Office of
Environment
& Heritage

Our Ref: DOC18/74075
Your Ref: MP10_160 – Stage 2 MOD 6

Re: White Rock Wind Farm project - Modification Proposal MP10_0160 MOD 6

Attachment 1: Detailed OEH Comments – Modification to the White Rock Wind Farm project (MP10_0160 MOD 6)

Figure 2.1 WRWF Indicative Stage 2 layout

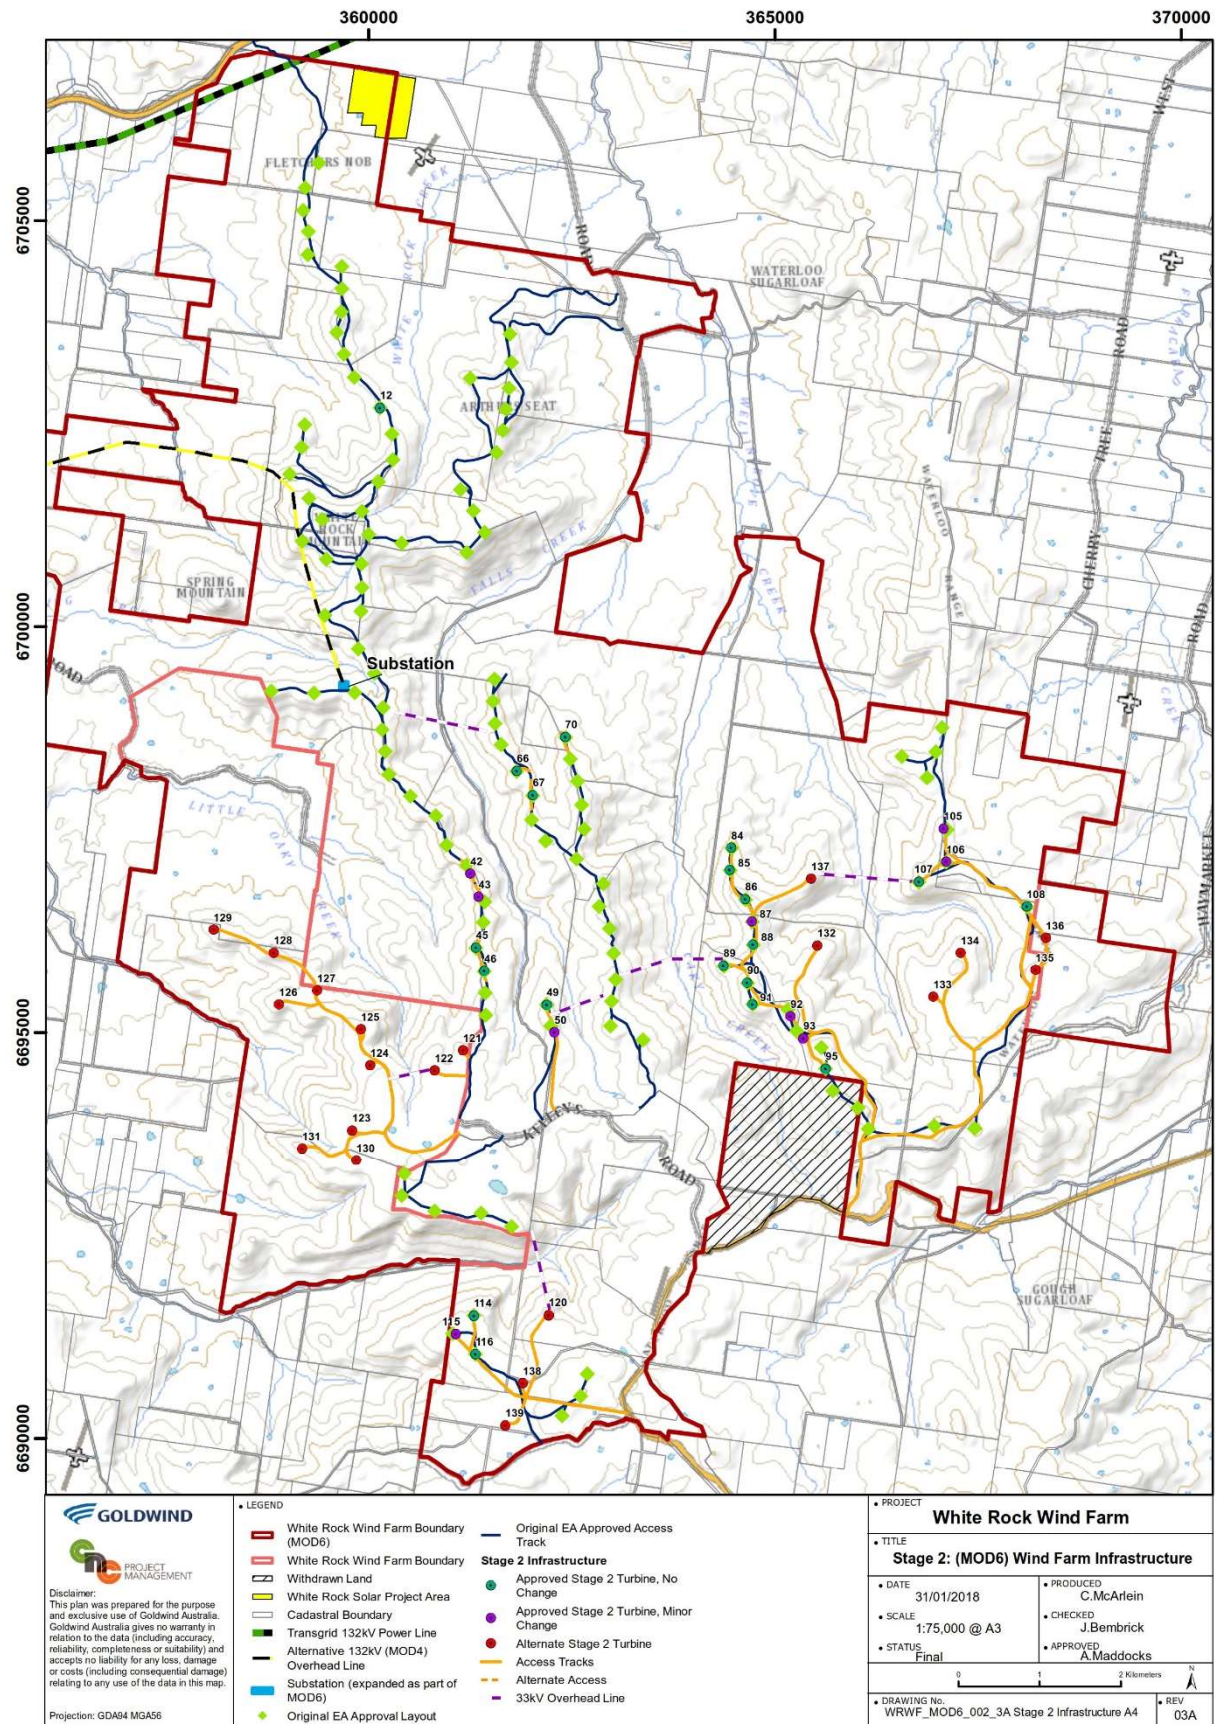
Comparison of the original Wind Farm layout and the proposed modification reveals a large change in development footprint, as set out in the map below, which shows the new locations for Stage 2 turbines (red dots) and tracks (connecting yellow lines). Turbines 121 through to 130 are in new locations in the western area of the subject site, as are Turbines 132, 133, 134, 135, 136, 137 in the eastern part of the site and Turbines 120, 138 and 139 in the south.

Although the number of turbines has not increased, the area of operation has been considerably expanded eastward and westward. In addition, the native vegetation clearing due to the new turbine locations, associated infrastructure and engineering details is over 220% greater than was originally approved. The increase is reportedly due to the original impact calculations under-estimating the impacts of tracks with the associated cut and fill and batter structures on steep slopes.
